Our Ref: M/157/18/PL
Your Ref:

Town & Country Planning Act 1990 (as amended)
Town and Country Planning (Development Management Procedure) (England) Order 2015
Application for Planning Permission

Development Replacement of existing timber shed
Location Communal Garden Elmer Sands Estate Adj 18 Manor Way Middleton on Sea

EAST ELEVATION (WEST ELEVATION SIMILAR)

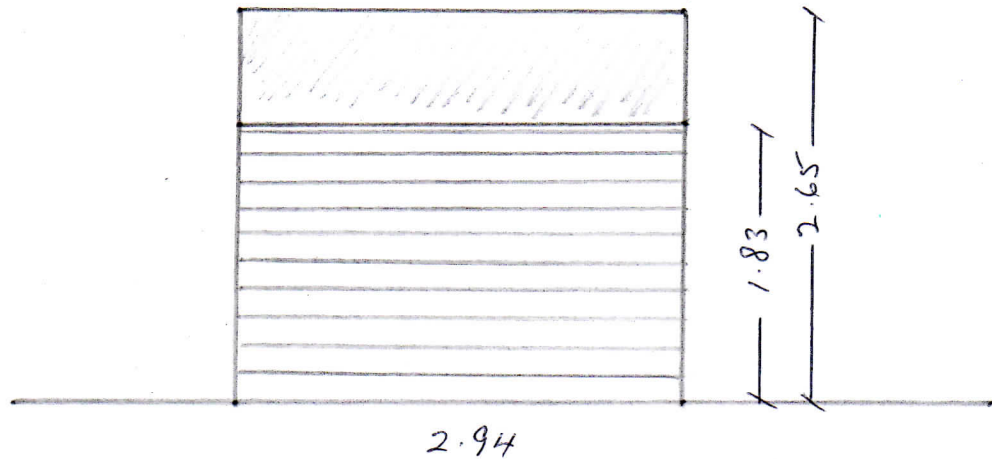
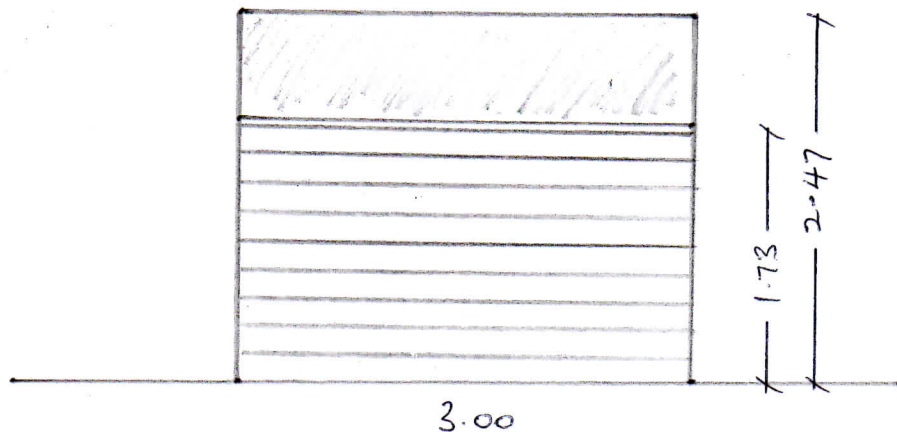
Please provide the proposed rear and other side elevations.

Communal Garden, Adjacent 18 Manor Way, Elmer, Middleton-on-sea, West Sussex, PO22 6JD

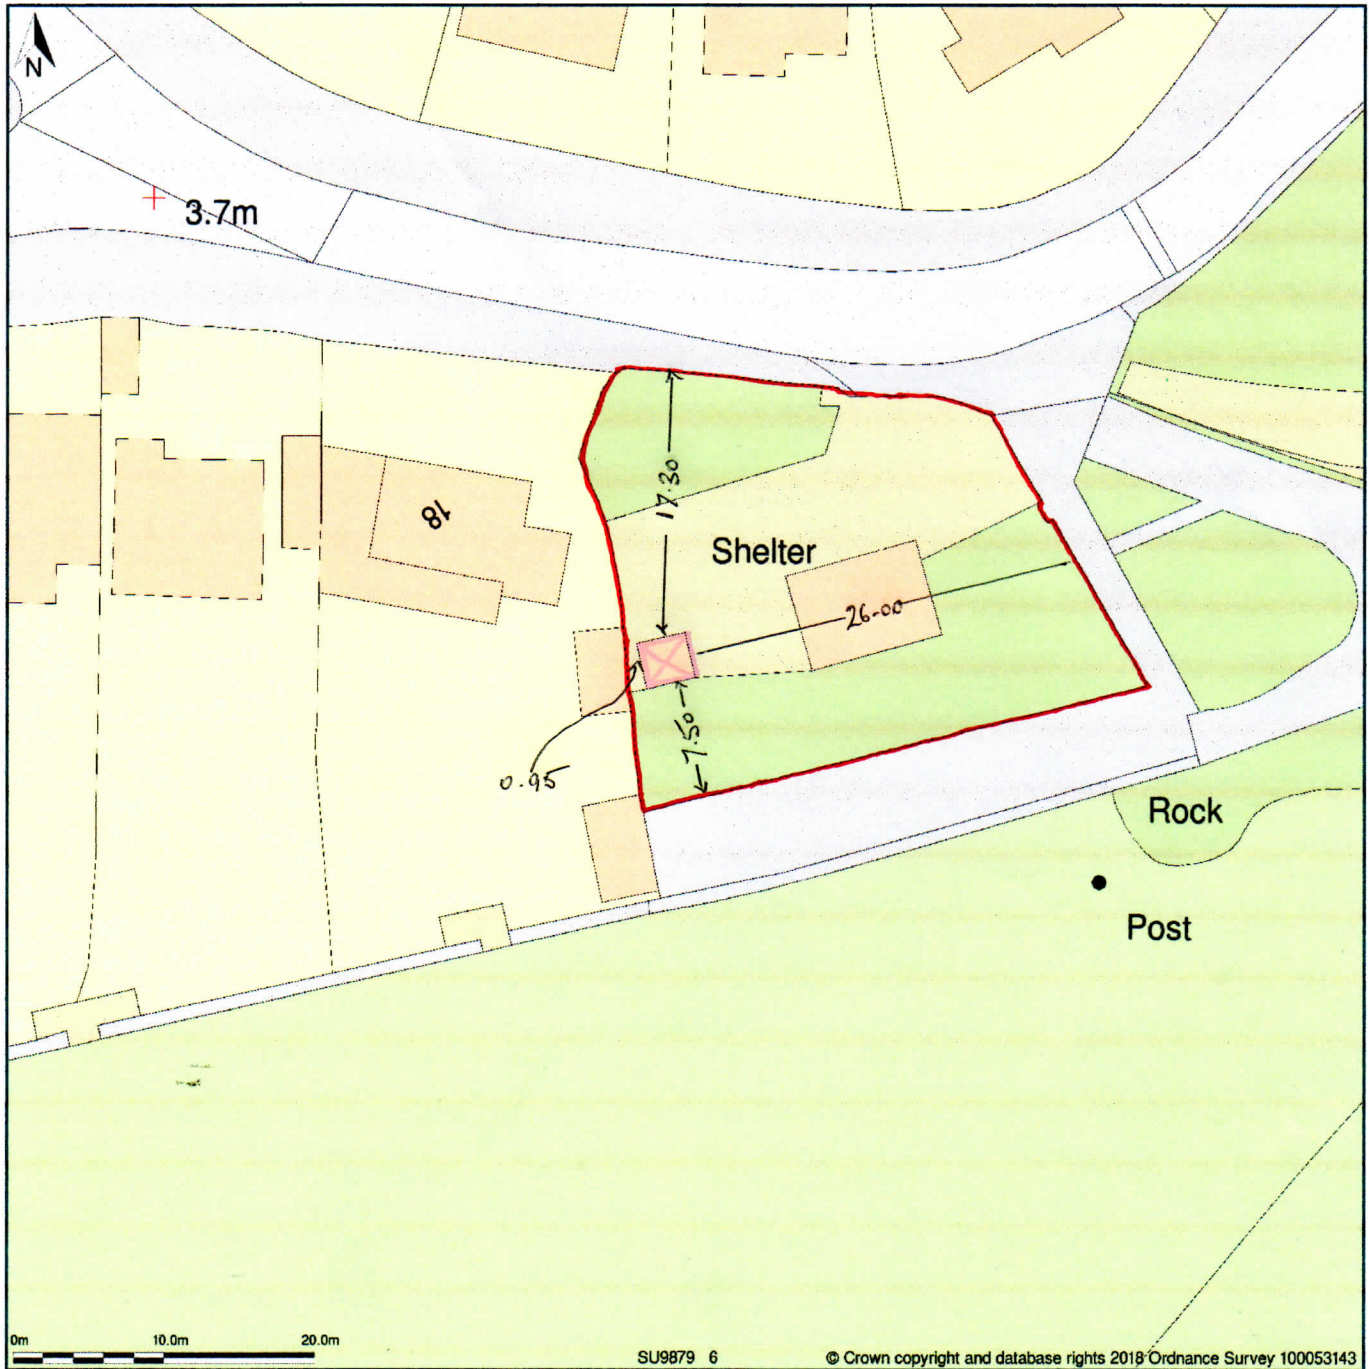
Block Plan Amend

Please provide measurements from the proposal the site boundaries.
